WELWYN HATFIELD COUNCIL – DEVELOPMENT CONTROL
DELEGATED REPORT

APPLICATION No:	S6/2010/2281/LU
------------------------	------------------------

The proposal is for a two storey rear extension, a loft conversion incorporating a rear dormer window, a single storey side extension and a garage conversion into habitable accommodation.

CLIENT DESIGN SERVICES LIMITED. 8 Timberdene Avenue, Barkingside, Essex, IG6 2LS. Tel. 020 8550 3320	EXISTING GROUND AND FIRST FLOOR PLANS	Date	Jun. 2010
	PROPOSED EXTENSION AND LOFT CONVERSION AT 45 KENTISH LANE, BROOKMANS PARK, AL9 6NG.	Scale	1:100 @ A3
		Dgn. No.	C10/56/CLU 02

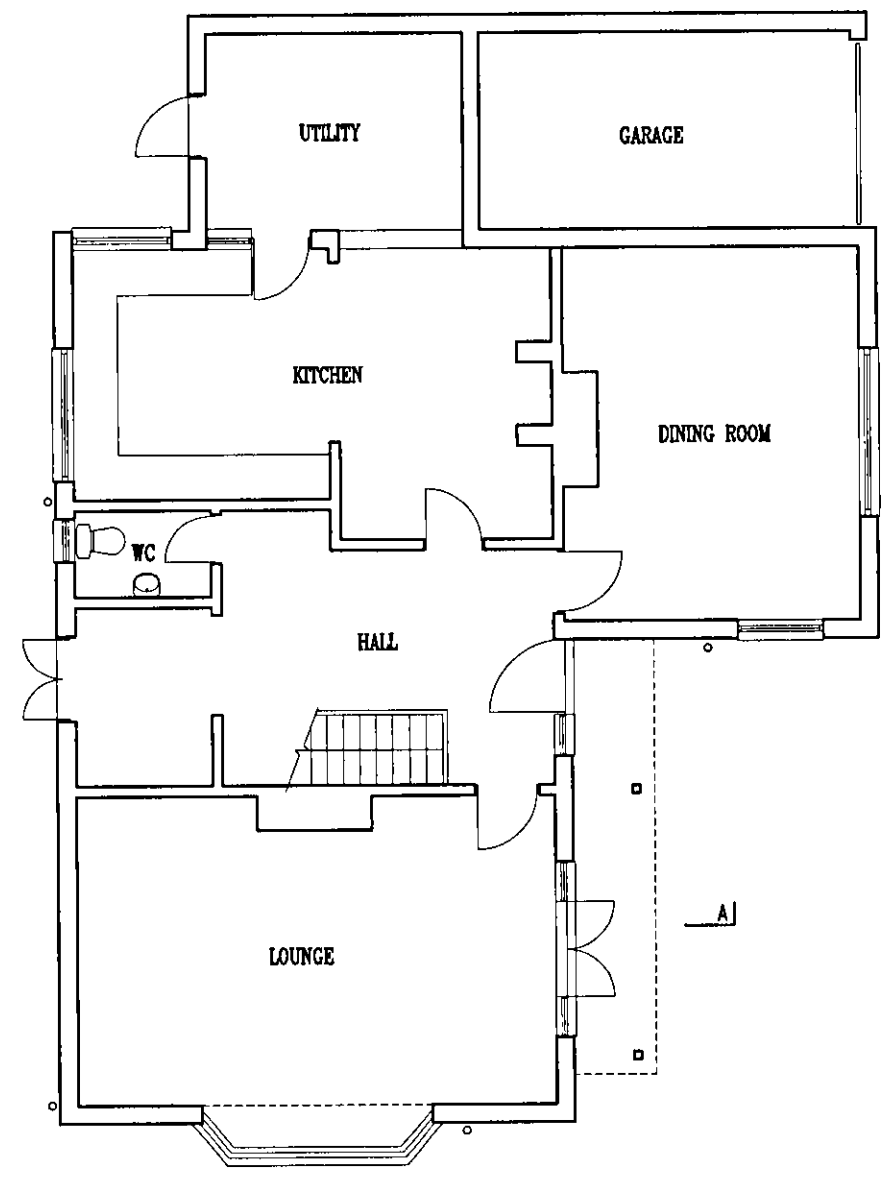
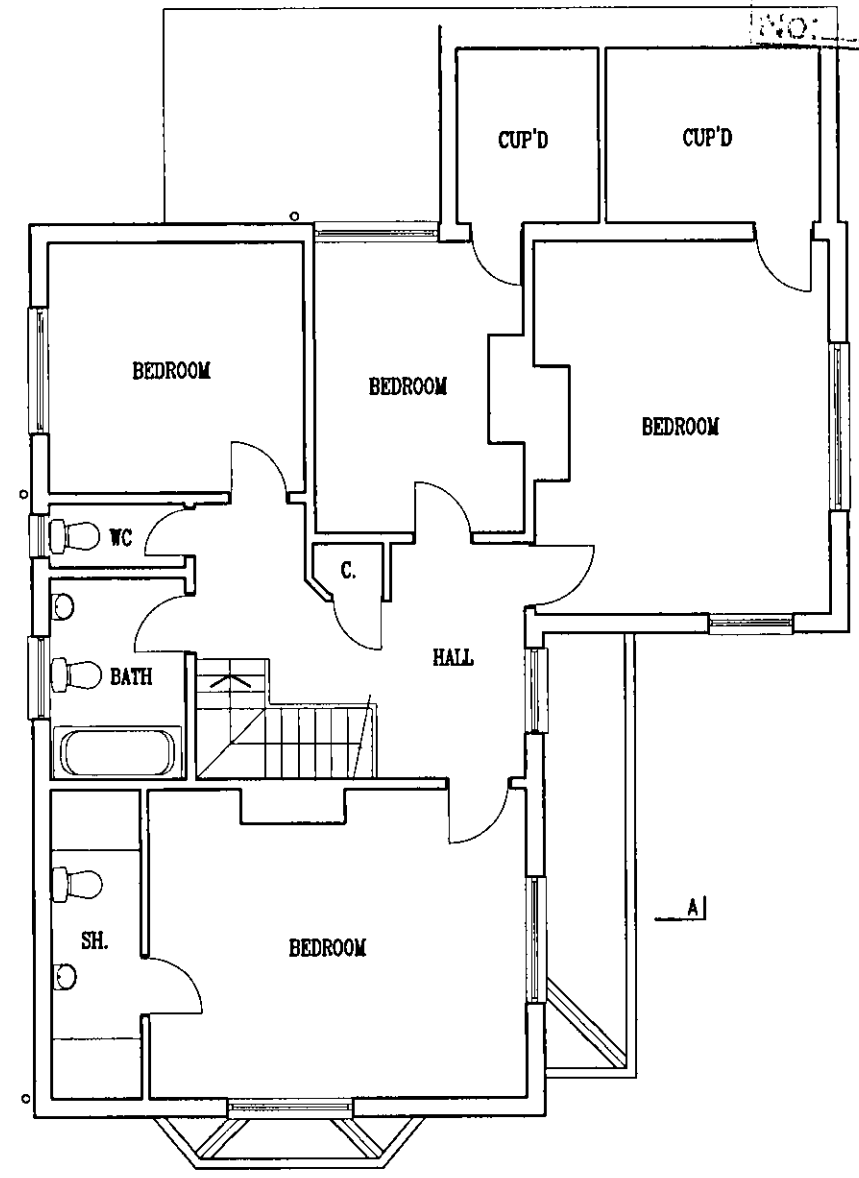
Roof above single storey side extension (shown as the utility on drawing no C10/56/CLU 02): (l) 3.65m x (h) 0.75m x (d) 2.8m = 7.67m³

|   |  | Dgn. No. | C10/56/CLU 07 |

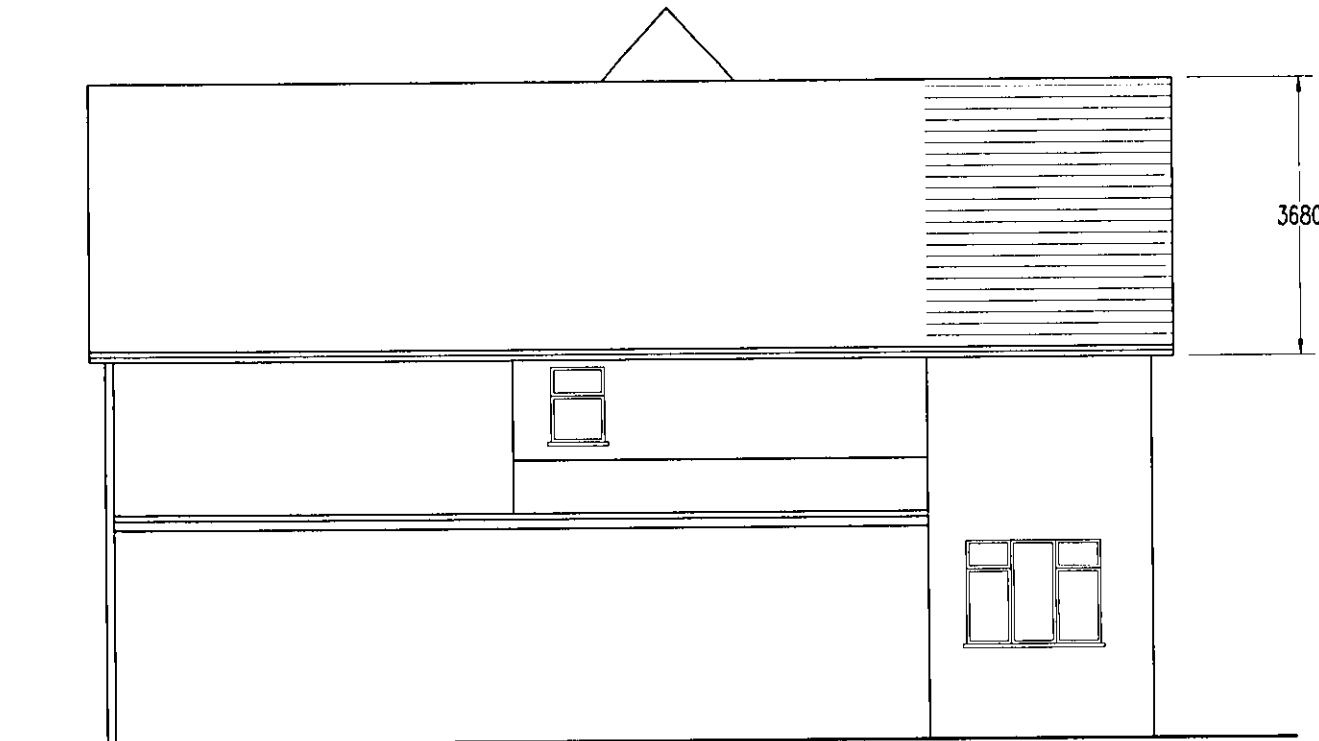
The proposed two storey rear extension measures three metres from the rear wall of the original dwellinghouse and more than 7 metres from the boundary of the curtilage opposite the rear wall of the dwellinghouse.

The proposed side extension on the north eastern side elevation of the existing dwellinghouse measures within two metres of the boundary and the height of the eaves measures 3 metres.

The proposed side extension on the north eastern side elevation extends beyond a wall forming a side elevation of the original dwellinghouse. The extension measures 3 metres in height, is single storey and has a width less than half the width of the original dwellinghouse.

The proposed side extension on the southern side elevation extends beyond a wall forming a side elevation of the original dwellinghouse. The extension measures 3.7 metres in height, is single storey and has a width less than half the width of the original dwellinghouse.

The pitch of the roof of the two storey rear extension matches the pitch of the original dwellinghouse.

CLIENT DESIGN SERVICES LIMITED. 8 Timberdene Avenue, Barkingside, Essex, IG6 2LS. Tel. 020 8550 3320	PROPOSED LOFT AND ROOF PLAN	Date	Jun. 2010
	PROPOSED EXTENSION AND LOFT CONVERSION AT 45 KENTISH LANE, BROOKMANS PARK, AL9 6NG.	Scale	1:100 @ A3
		Dgn. No.	C10/56/CLU 06

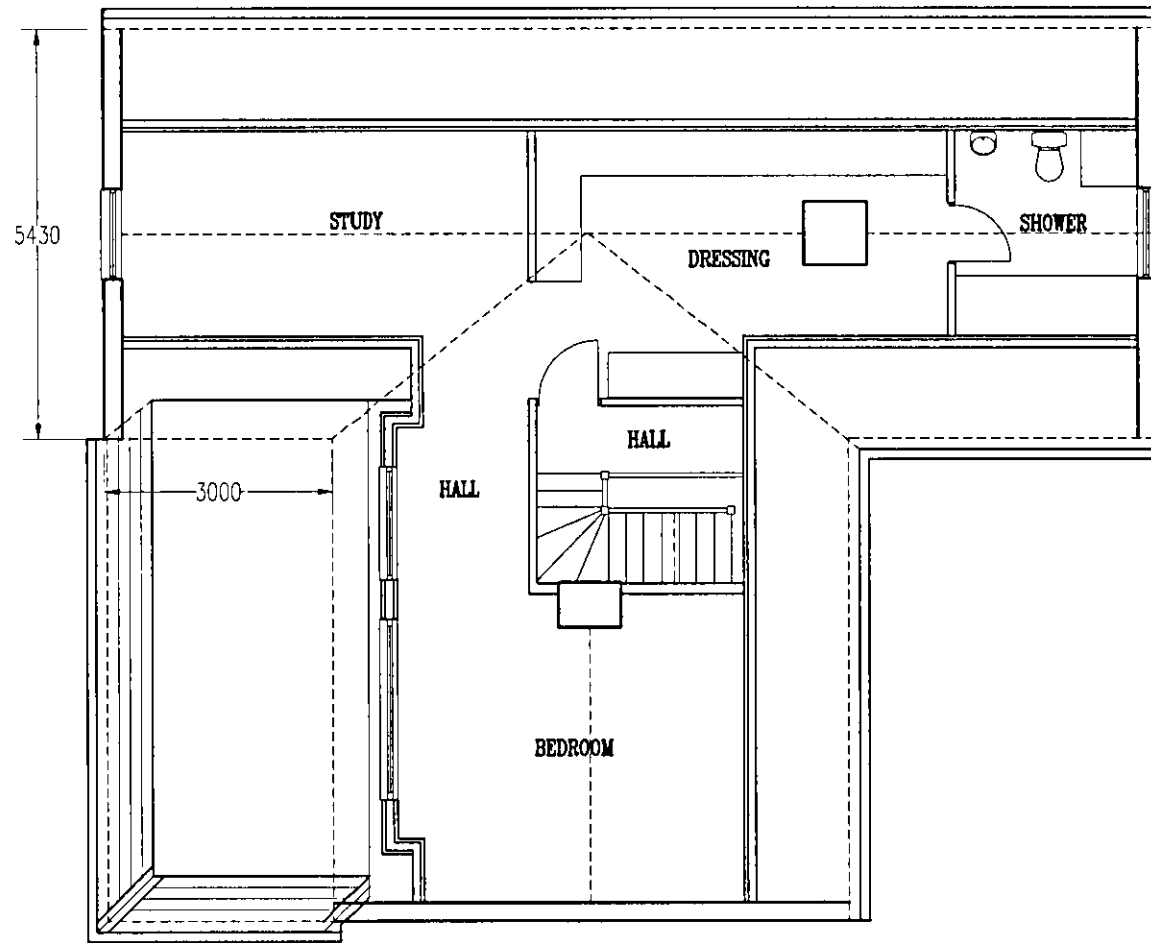
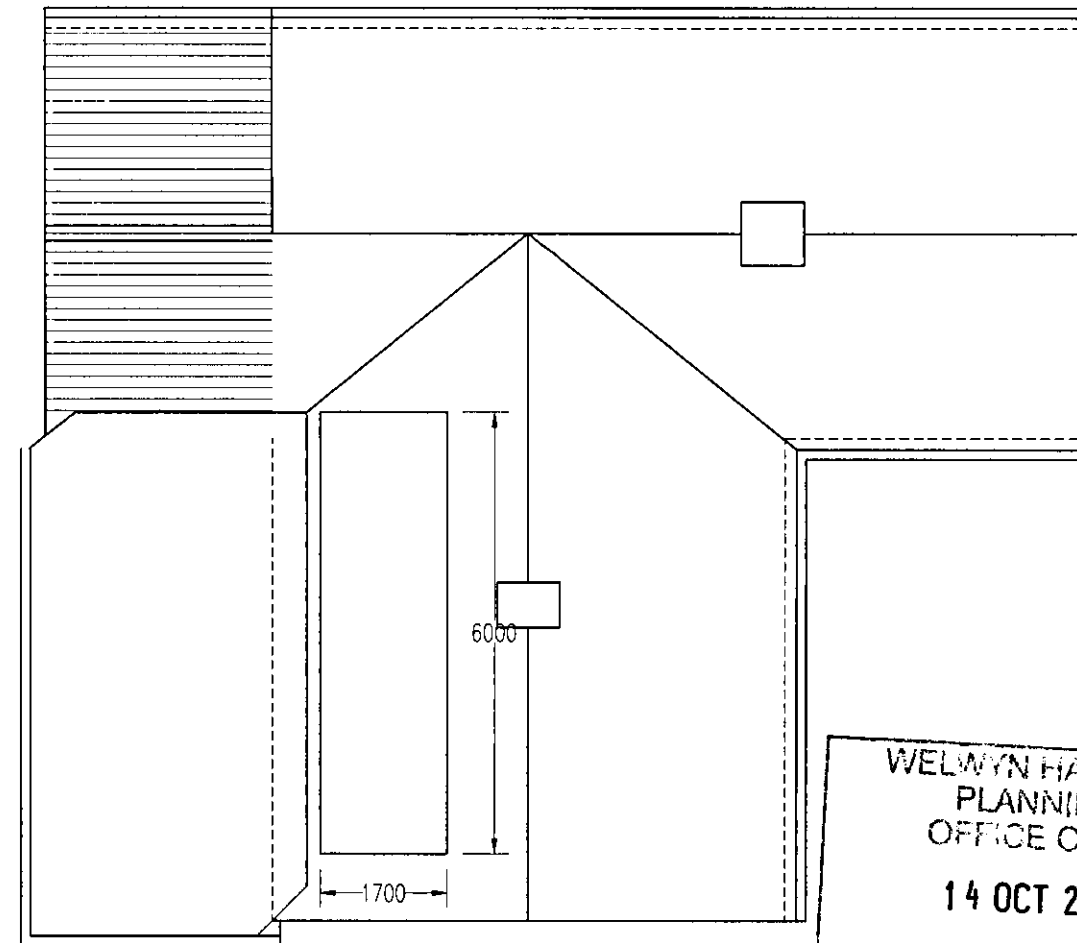
Rear dormer window: (l) 5.85m x (h) 1.95m x (d) 1.5m / 2 = 8.2m³

Roof above two storey rear extension: (l) 6.5m x (h) 3.5m x (d) 3.25m / 2 = 37m³

Plus: (l) 6m x (h) 1.3m x (d) 2.75m = 21.45m³

Roof above extension to existing single storey extension: (l) 1.75m x (h) 0.75m x (d) 2.8m = 3.68m³

Total additional floorspace: 7.67m³ + 8.2m³ + 37m³ + 21.45m³ + 3.68m³ = 78m³

The proposed development fails to comply with Schedule 2, Part 1, Class B of the Town and Country Planning (General Permitted Development) Order 1995 as amended by the Town and Country Planning (General Permitted Development) (Amendment) (No.2) (England) Order 2008 by virtue of the additional roofspace exceeding 50 cubic metres.
